From: Lol Pilfold [REDACTED]
Sent: 05 June 2018 08:11
To: Anita Gardner
Subject: Fwd: Planning Application EP/7/18

From: Lol Pilfold [REDACTED]
Date: 1 June 2018 at 14:01
Subject: Planning Application EP/7/18
To: Anita Gardner <Anita.Gardner@arun.gov.uk>

DRAWING TITLE
Proposed Site Plan, Block Plan
and Location Plan

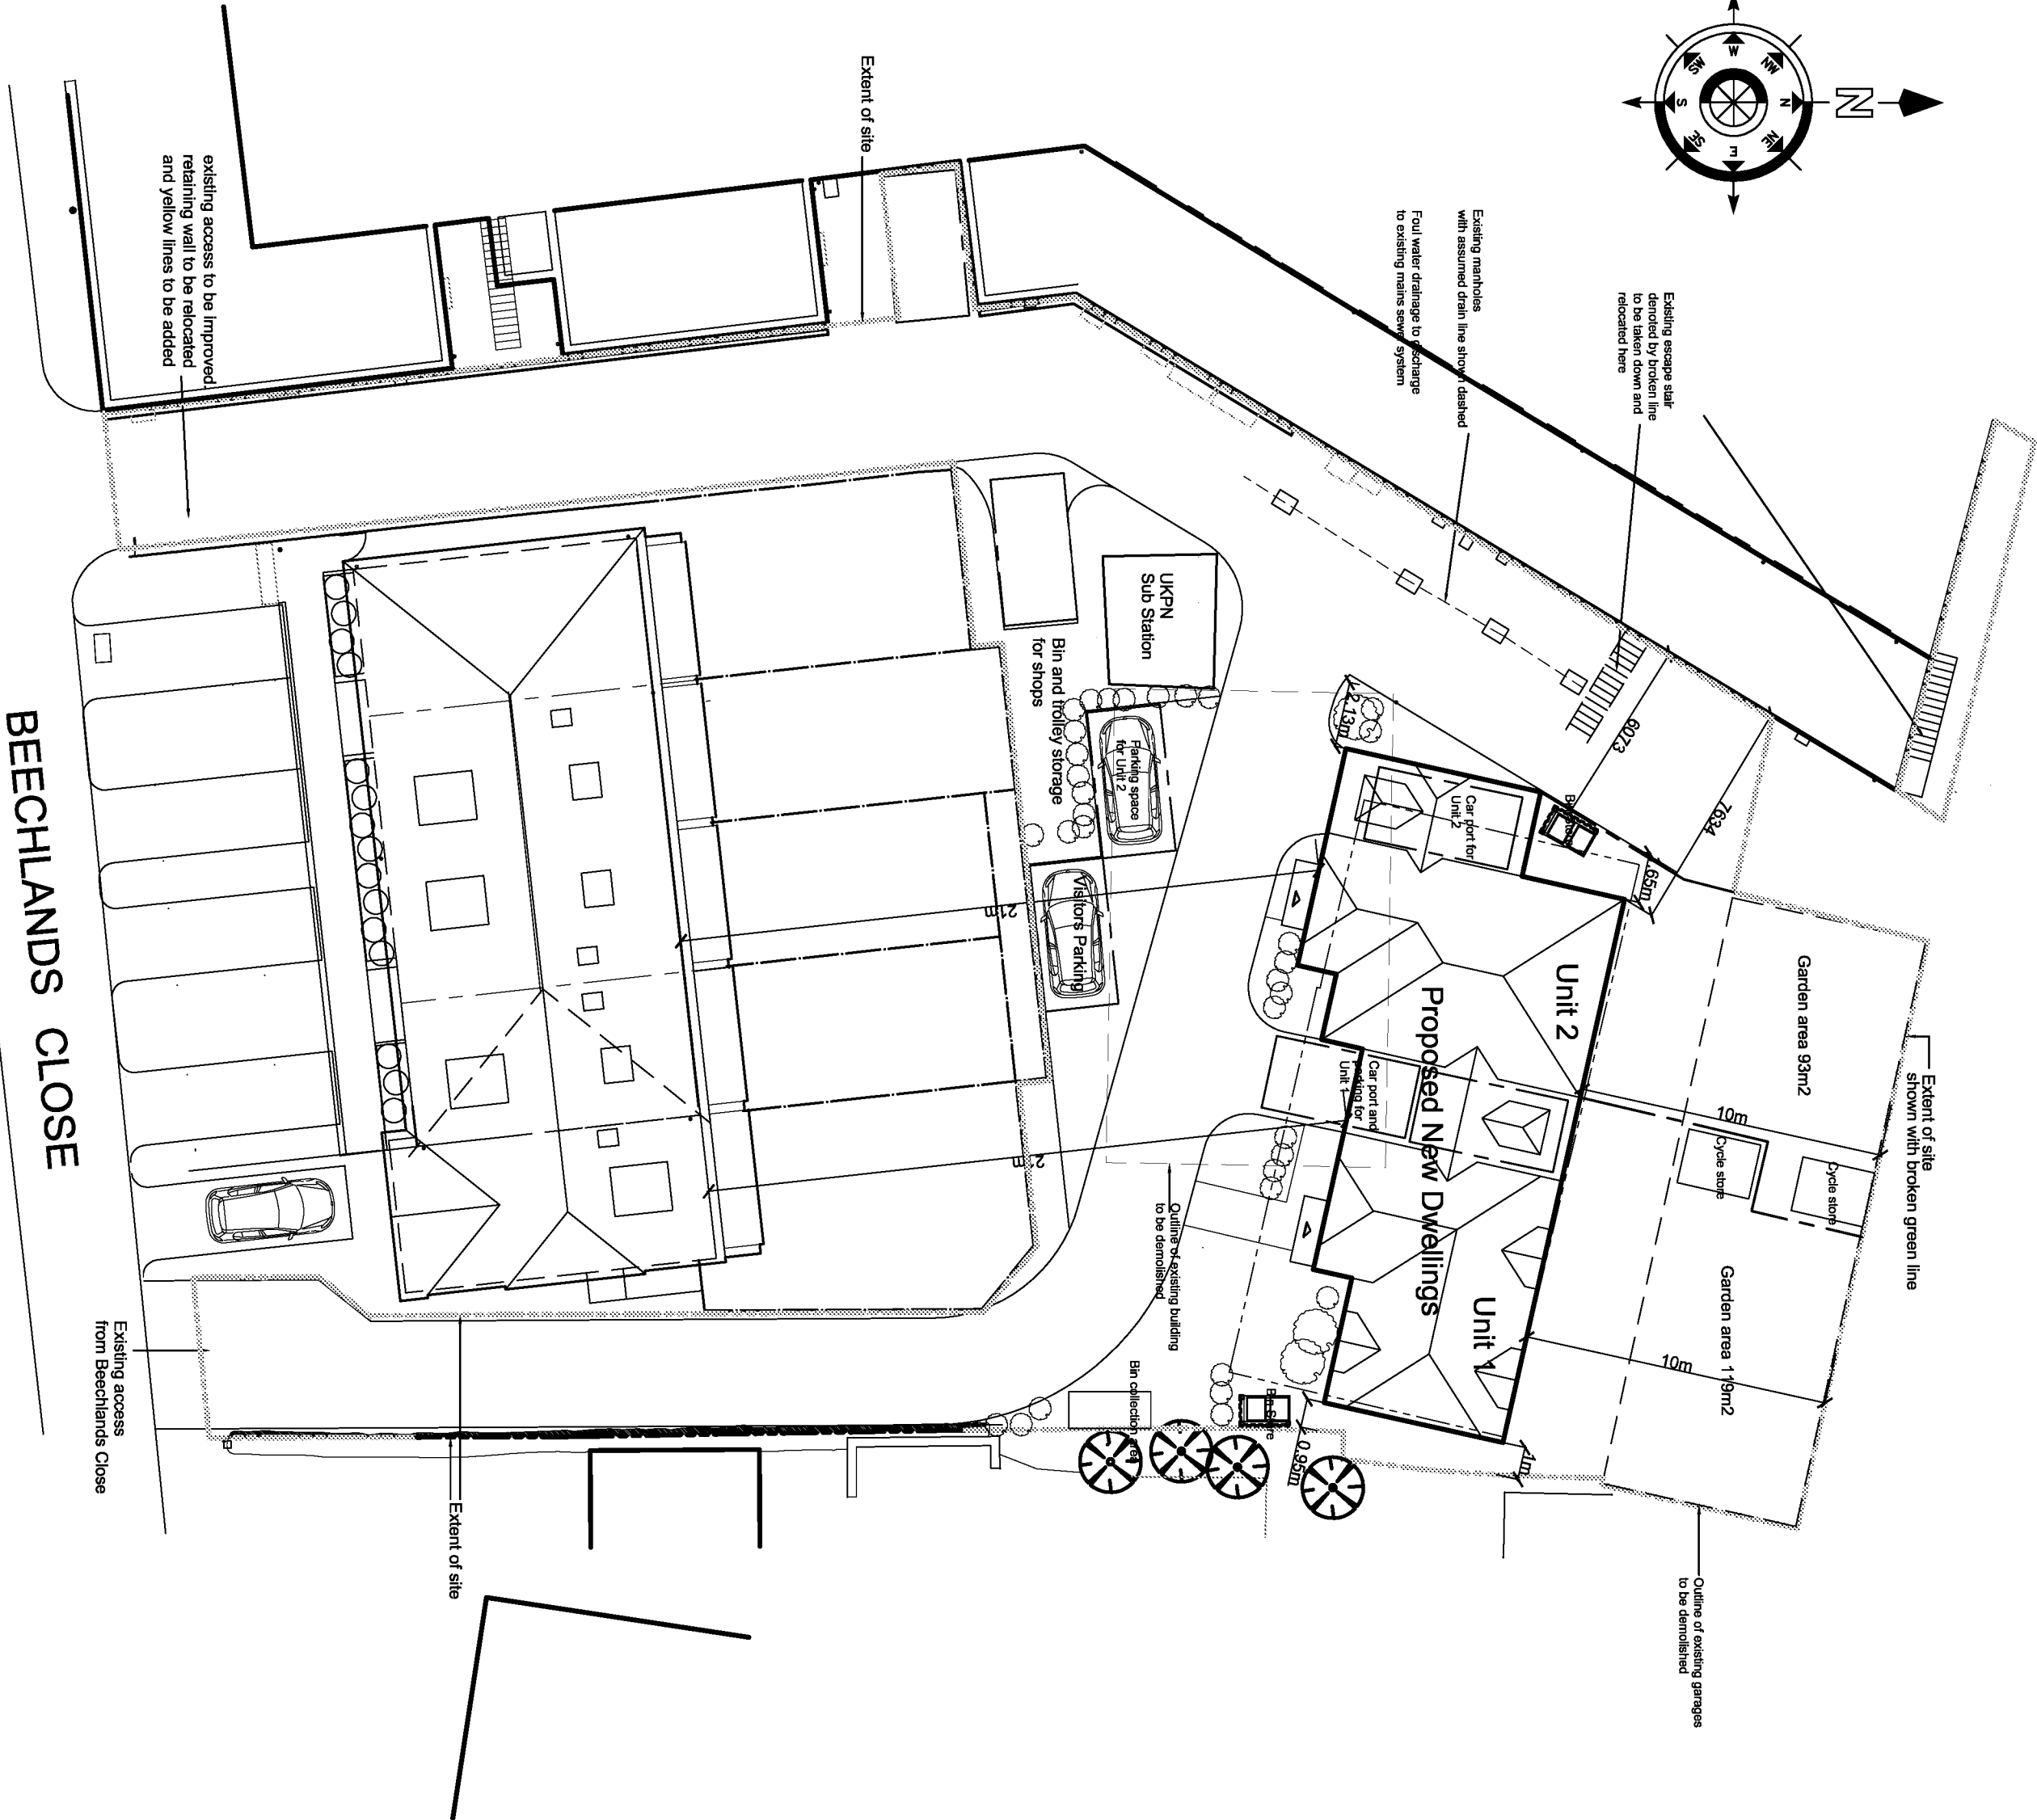
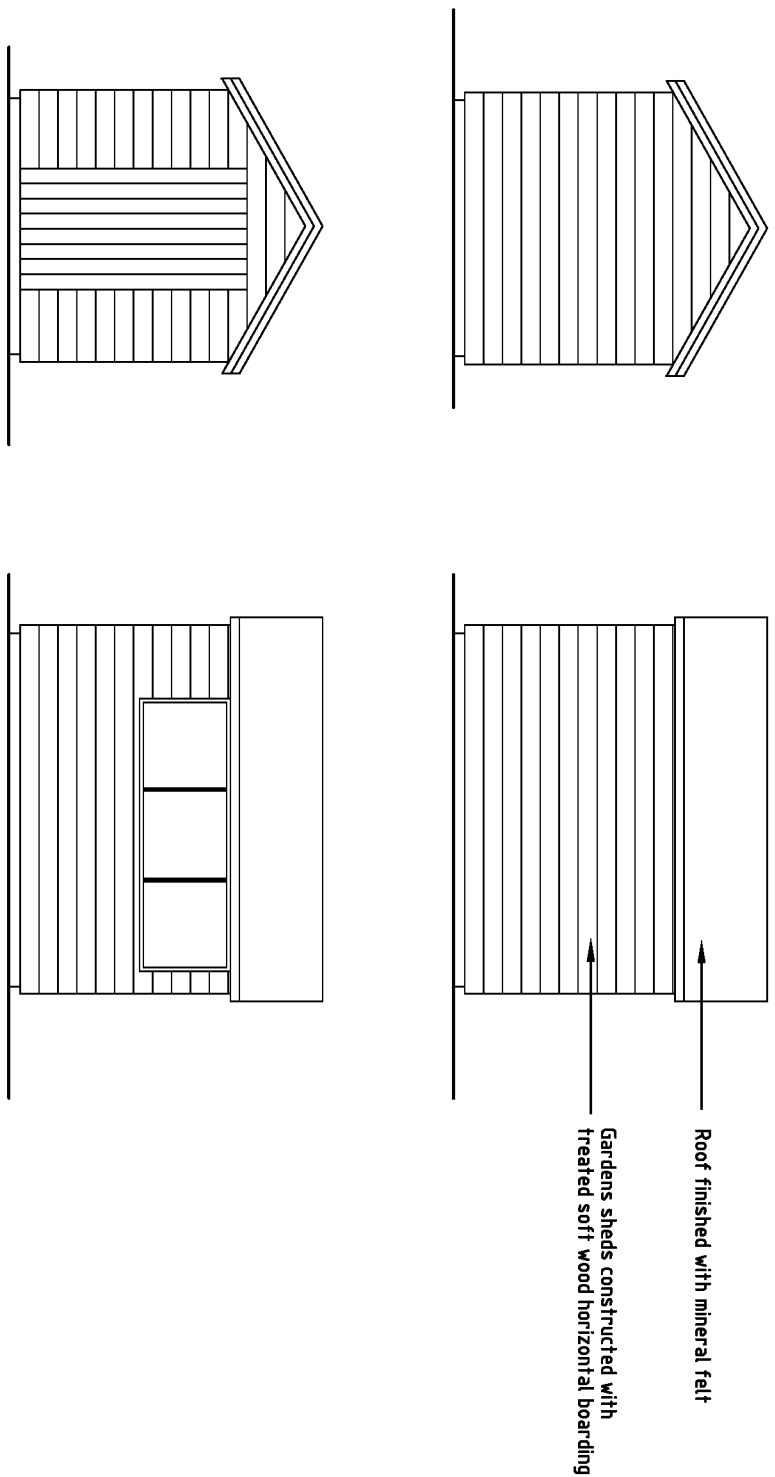
Do you think it would be possible to indicate where our proposed parking will be on the plan ?

them. Parking will presumably be required for any operatives working on the sub-station along with their plant ,so again could I ask where this is shown on the plan ?

Any large delivery vehicles attempting to manoeuvre into this "improved access" would require to ride over the kerbs and pavements (as "One Stop" are allowed to do) due to the restrictions coming in from, and then presumably reversing back into Beechlands Close (blind) ..or is there a turning area ?
